# CITY OF ALBUQUERQUE

RE: **Prima Entrada Lots 1-7**  
**9500 Sonterro Ave NW**  
**Grading and Drainage Plan**  
**Engineer's Stamp Date: 5/6/19**  
**Hydrology File: J09D020A**

Based on the submittal received on 5/6/19, this Grading and Drainage Plan cannot be approved until the following are corrected:

1 SECTION AT PROPERTY LINE
Scale: 1:5

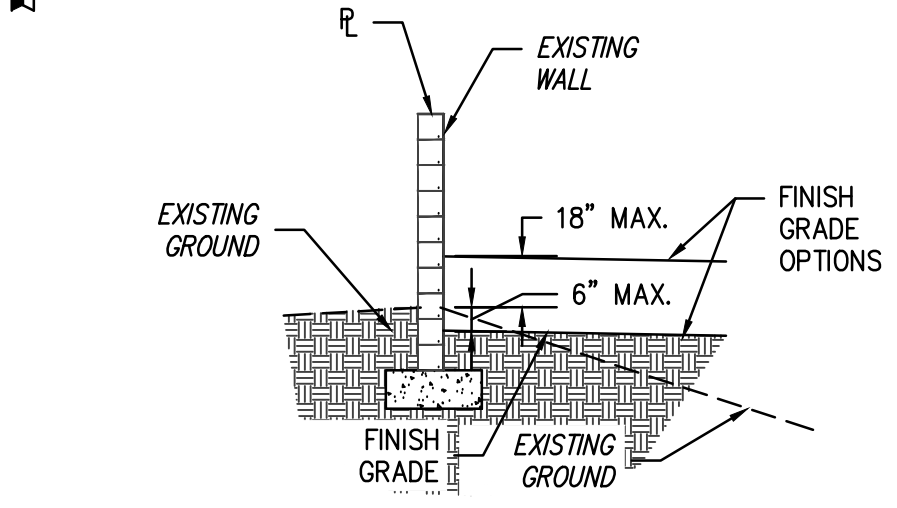
- a. Section 1-1 does not show property line and the wall should be called out as proposed. Hydrology recommends specifying a max permissible grade change (~18" for garden wall); right now the plan indicates that no grade change is allowed.

2 SECTION AT PROPERTY LINE
Scale: 1:5

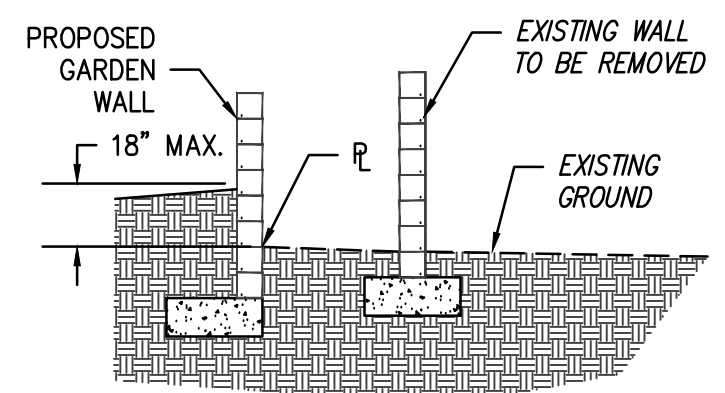
- b. Section 1-2 does not show property line. This existing wall appears to have a retaining wall at its base; please confirm. The max permissible grade change should be specified for cut and fill, as both cases will occur per your grading plan.

3 SECTION AT PROPERTY LINE
Scale: 1:5

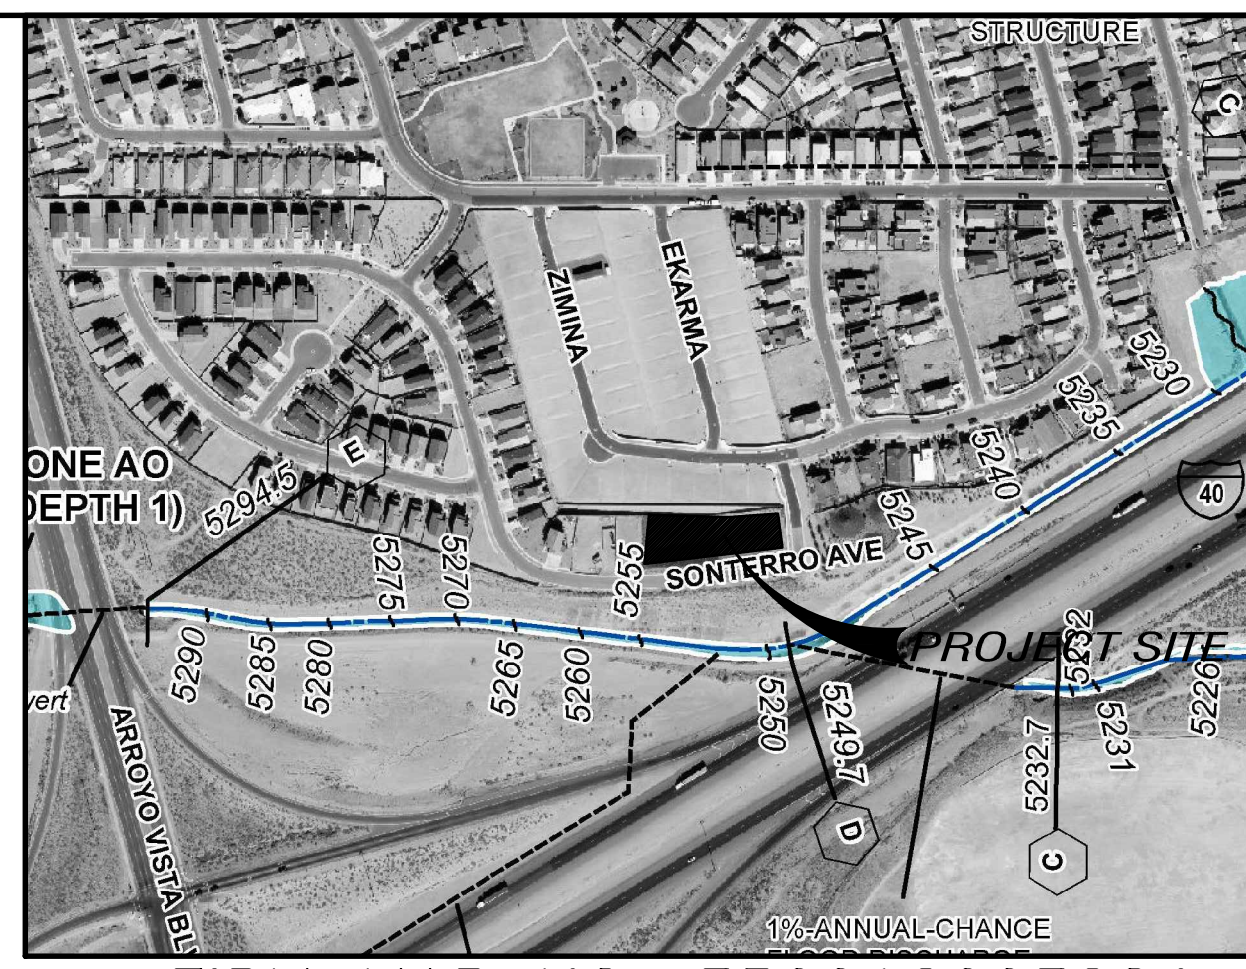
- c. Section 1-3 does not show property/ROW line. This wall was built in the ROW and will need to be removed and rebuilt on private property as part of this project. Alternatively, you can obtain a Revocable Permit for the encroachment (prior to Final Plat) or vacate the ROW (Prior to Final Plat). The plan needs to show which option will be pursued. Hydrology recommends specifying a max permissible grade change (~18" for garden wall); right now the plan indicates that no grade change is allowed.
